12/13/2023

SUBJECT: BRES2009-0022
BUILDING RESIDENTIAL

Here are the results of all Inspections located at **8296 CHRISTIAN LIGHT RD:**

FOUNDATION PLAN

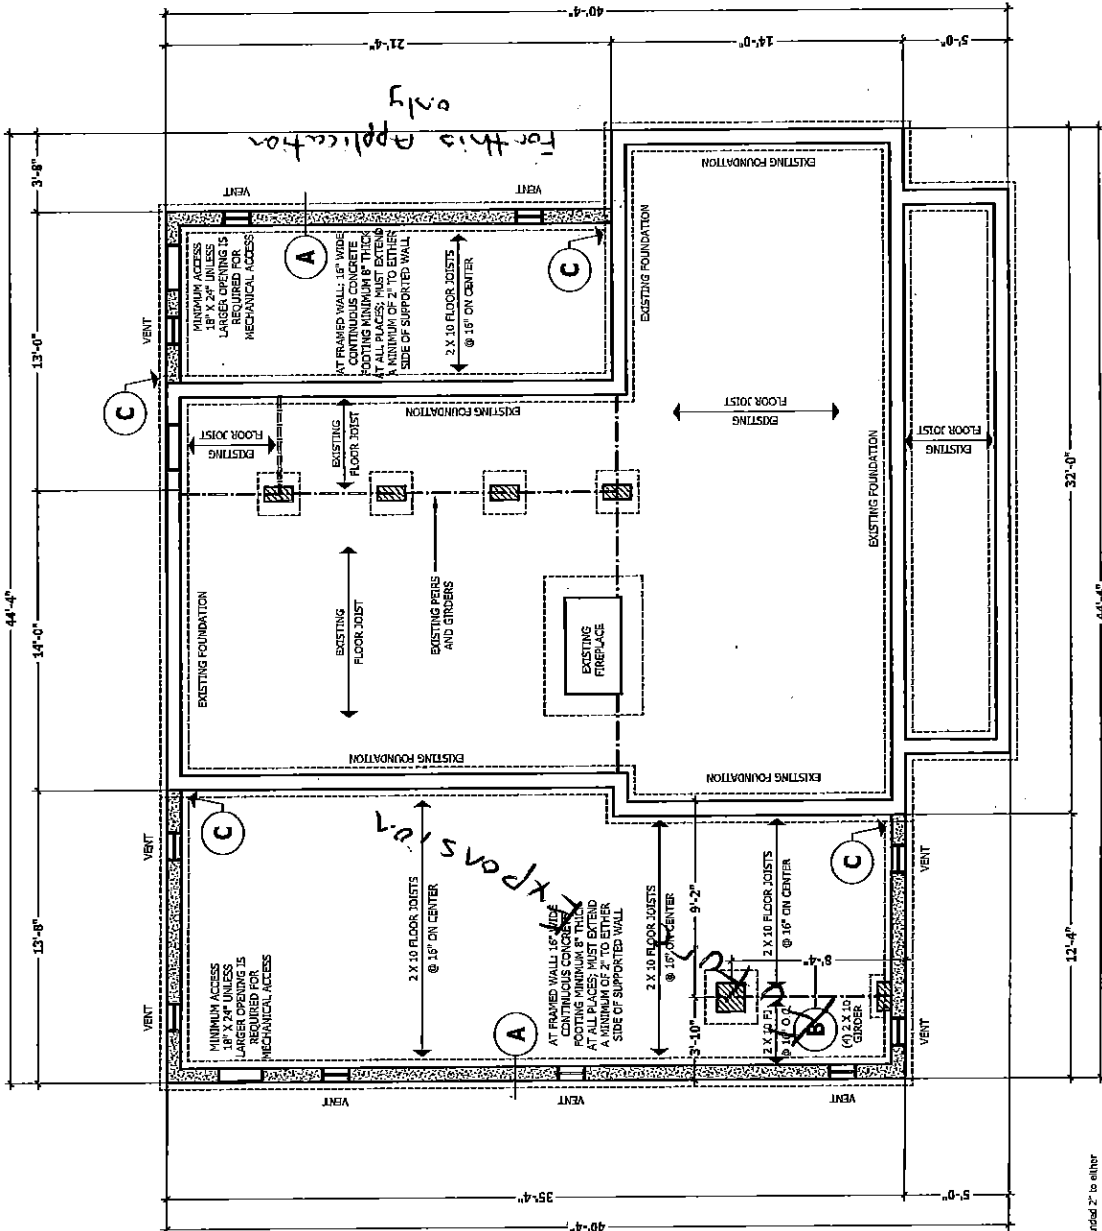
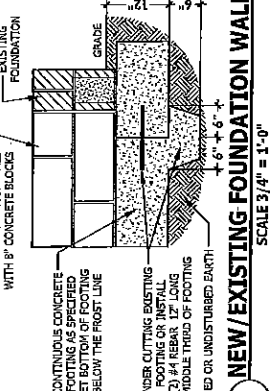
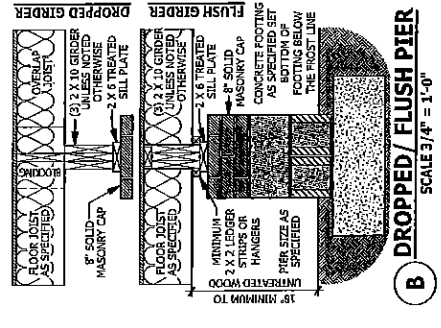
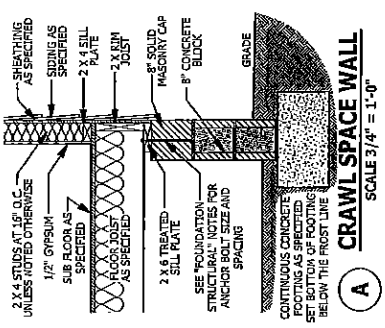
Need engineer letter for footings that have no been inspected according to permit.
